Recommendation Report for Lawful Development Certificate for a Proposed Use or Development

REF NO: LU/273/18/CLP

LOCATION: 9 Rosemead
Littlehampton

PROPOSAL: Lawful development certificate for a proposed rear dormer window, with Juliet Balcony, No.2 Velux windows to the principle roof elevation and proposed no.1 side window

Proposals 04 A

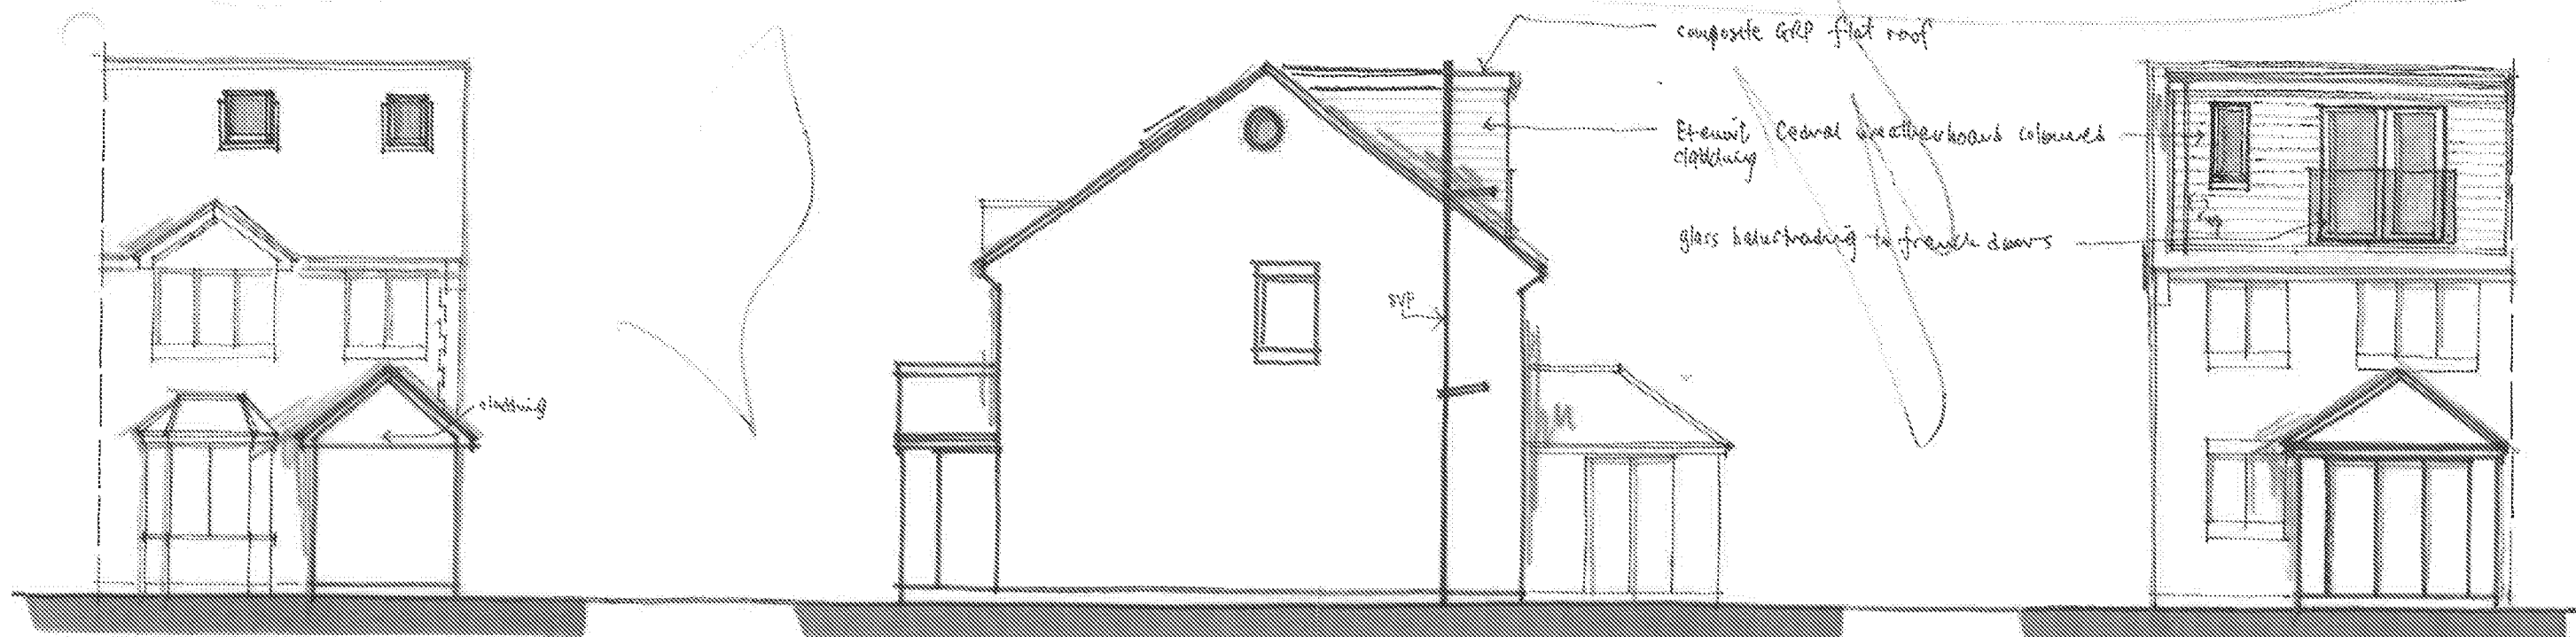
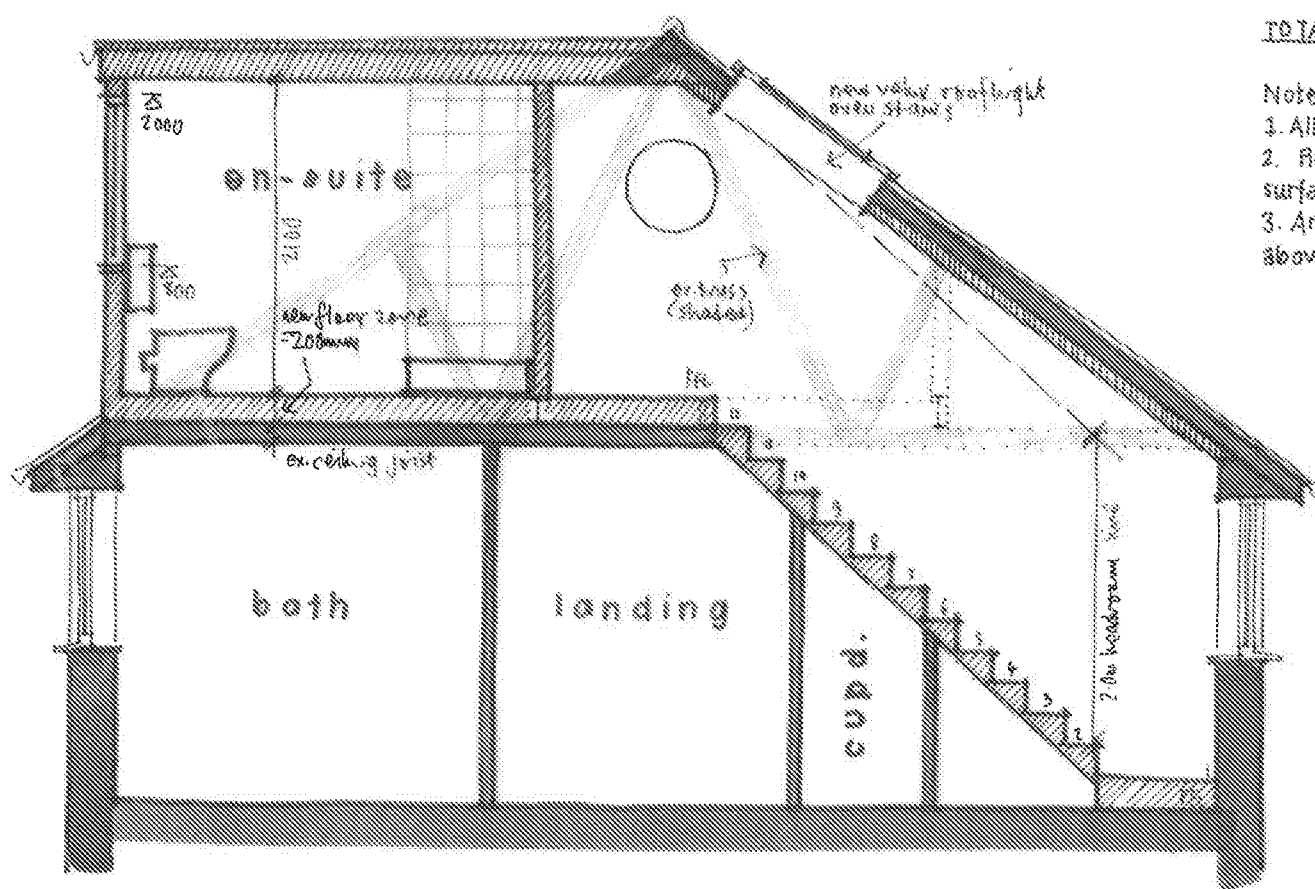
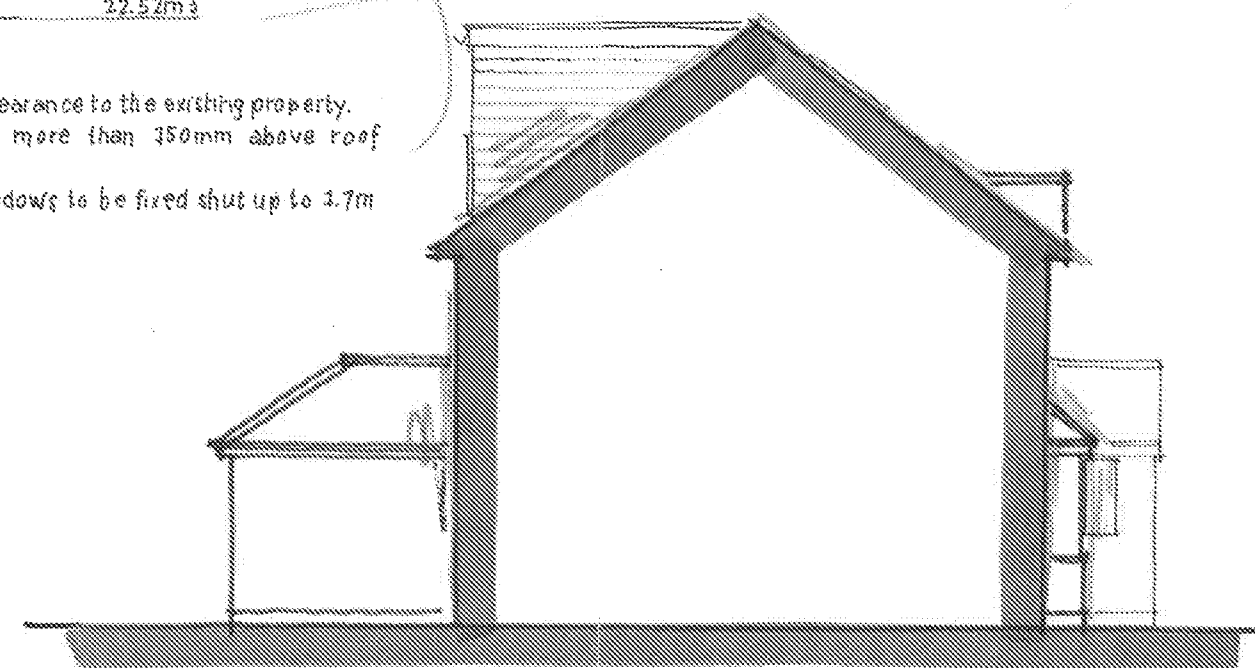
(The cubic content of the roof as proposed would measure 22.52m³, and therefore would not exceed 50 cubic metres as above)

(the material finishes as listed on plan 4A, are considered as similar in appearance to the existing dwelling ; windows material & Cladding)

(the eaves of the original roof are maintained at approx 0.4m)

(The side window would be finished with obscure glass and fixed shut as confirmed on Plan 04A)

(the Velux windows would not project beyond 0.15m above the plane of the principle roof slope)
